## Application for a Non-Material Amendment Following a Grant of Planning Permission

Erection of a two storey side extension, and single storey rear extension, following demolition of existing garage and utility room, including internal alterations and changes to fenestration.

23/1052/FFU

DETAIL:
PROPOSED ELEVATIONS

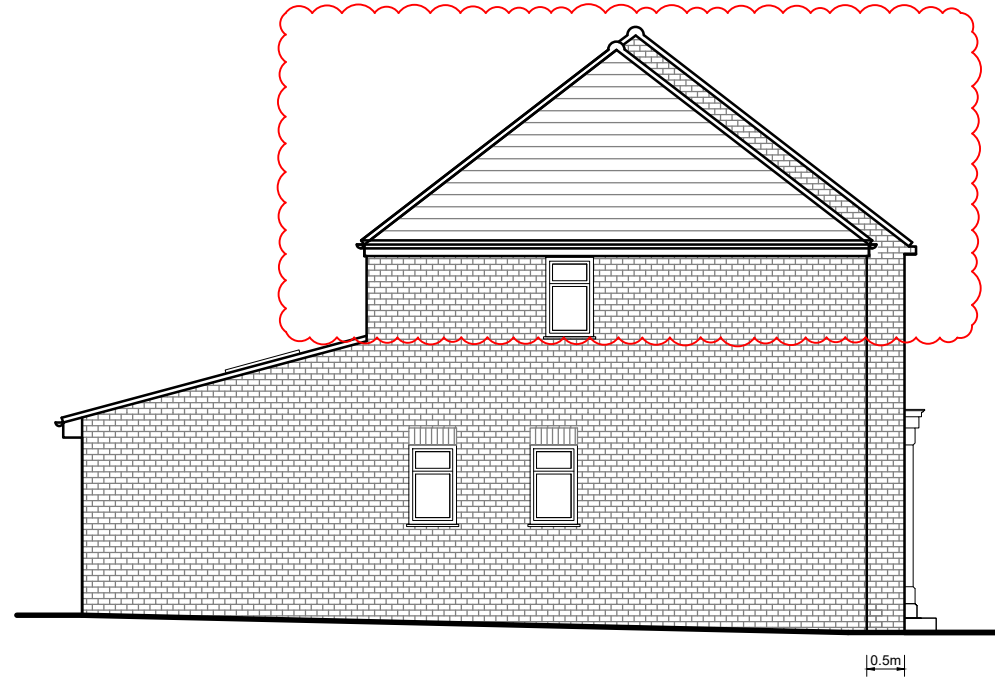
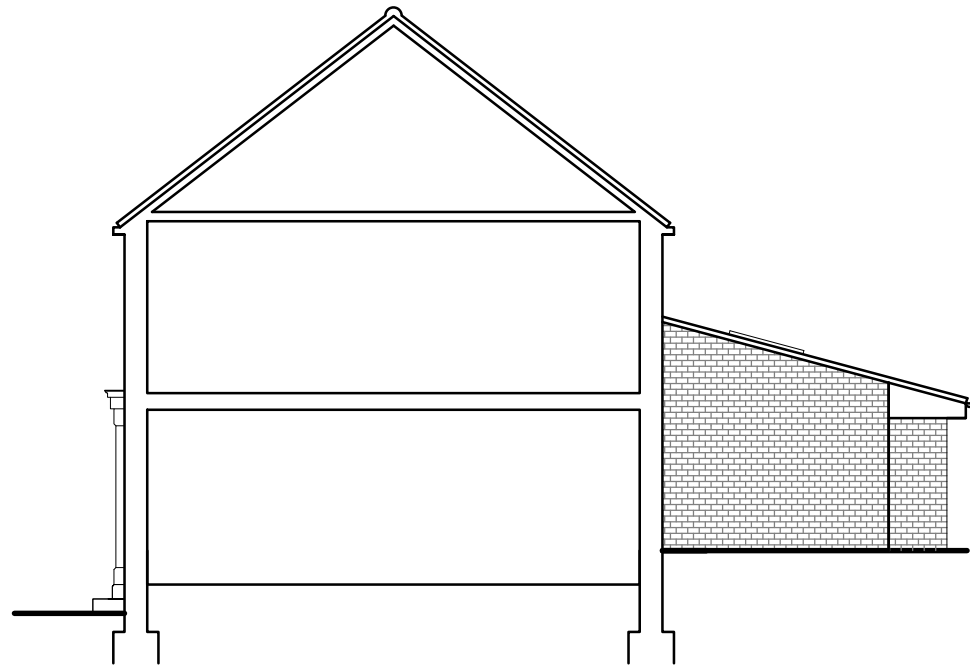
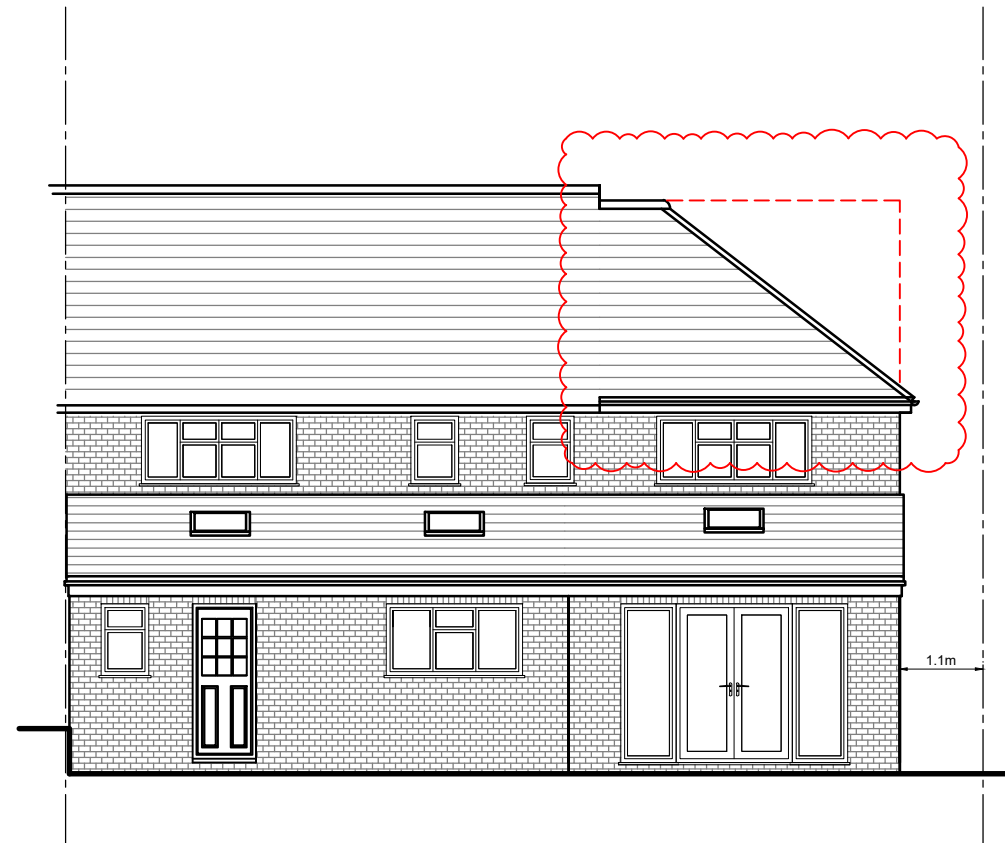
Gable roof changed to hipped roof.

Reduce impact on neighbour after they raised concerns.

Proposed Elevations rev B
